From: Susan Haley <Susan.Haley@arun.gov.uk>
Sent: 26 August 2026 11:05
[REDACTED]
Subject: A/105/26/HH - 1 Drift Road, BN12 6RD

I have been allocated application A/105/26/HH - 1 Drift Road, BN12 6RD but see that two location plans have been submitted. Please could you confirm which is correct and I will remove the other.

1 Drift Road, BN12 6RD

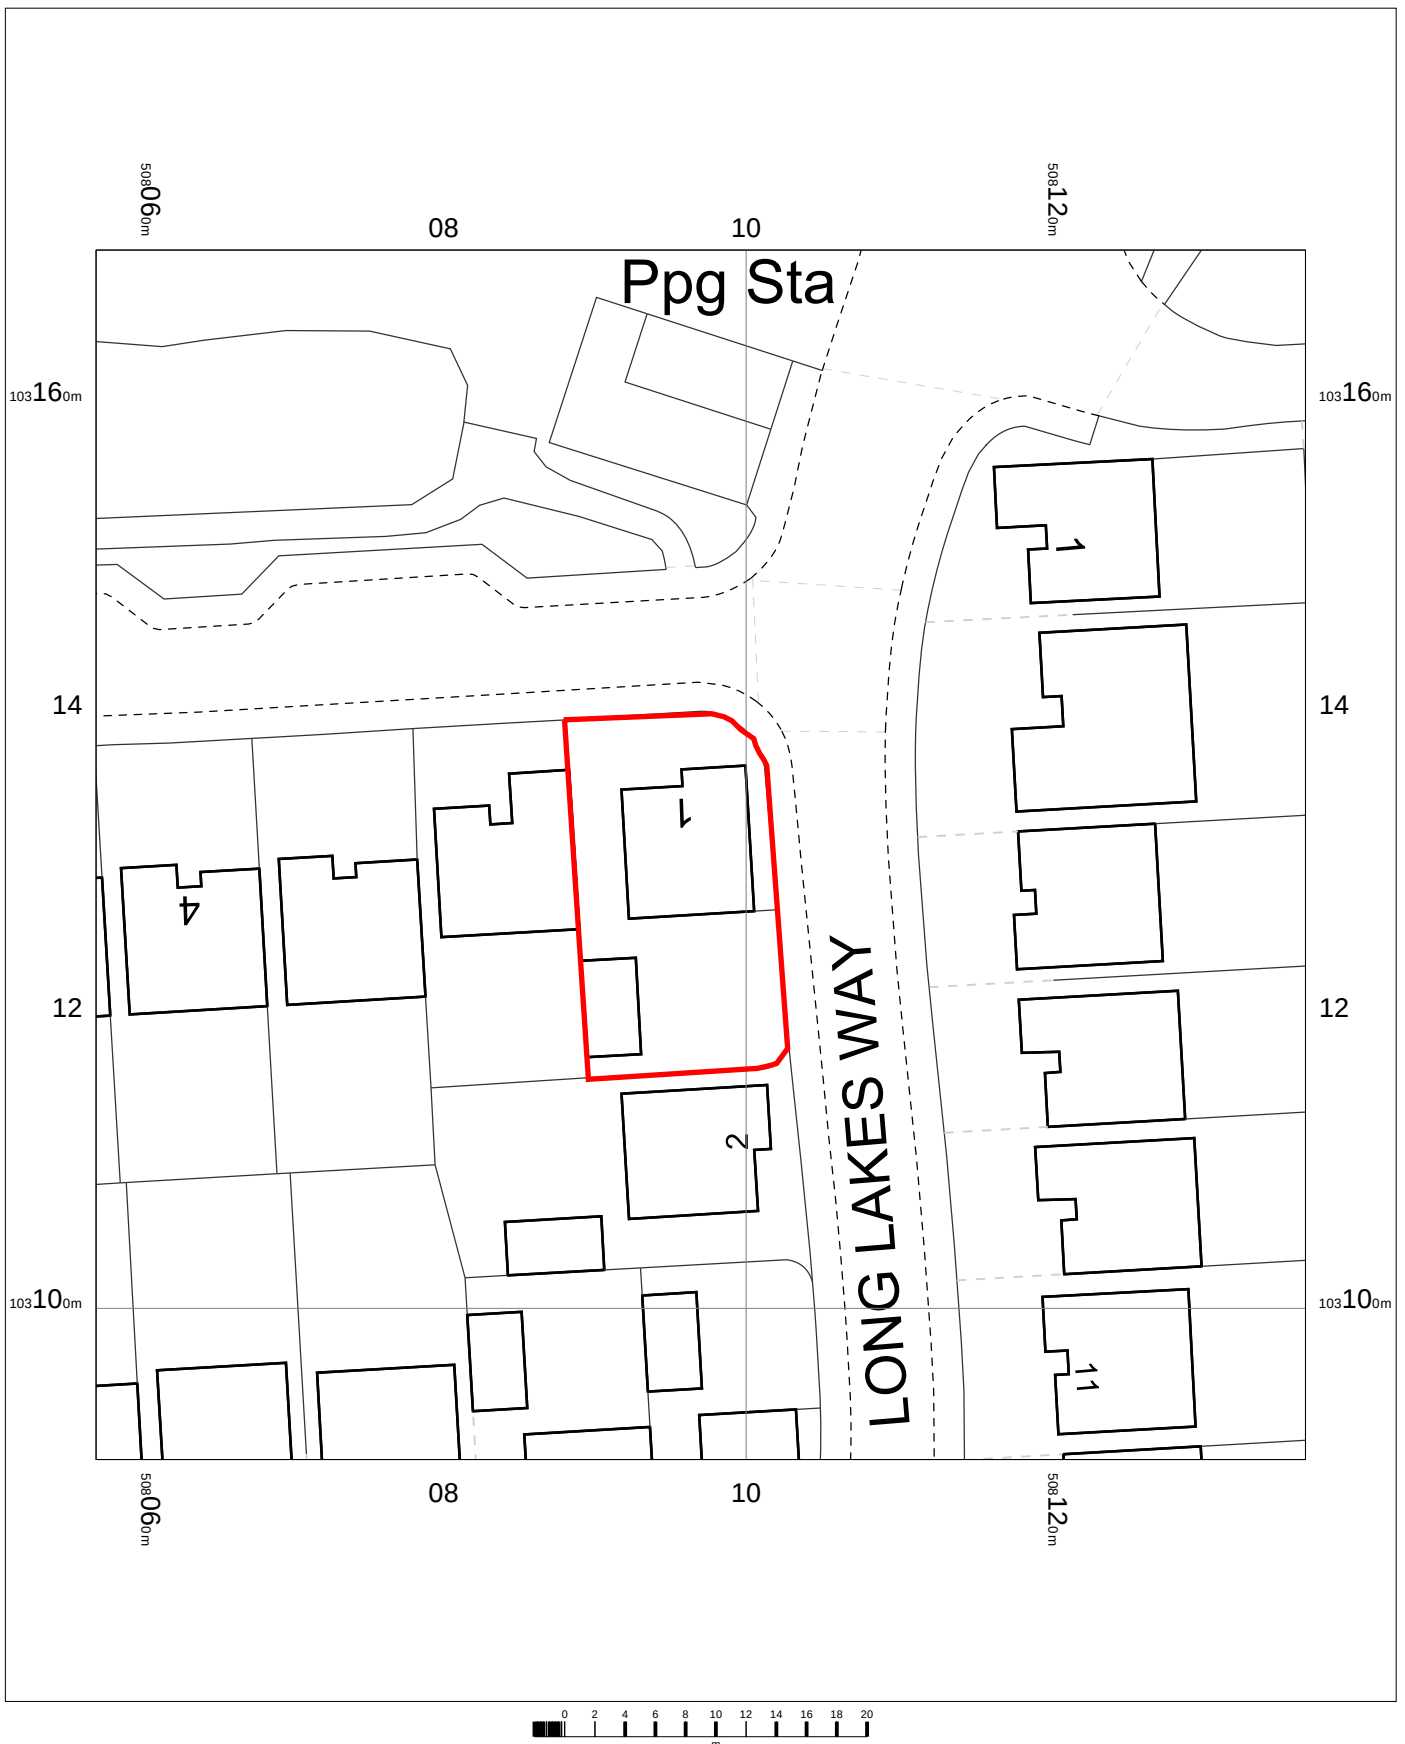
Additionally, please amend the block plan to indicate the proposal so that it is clear to the public.

Clearer block shown attached
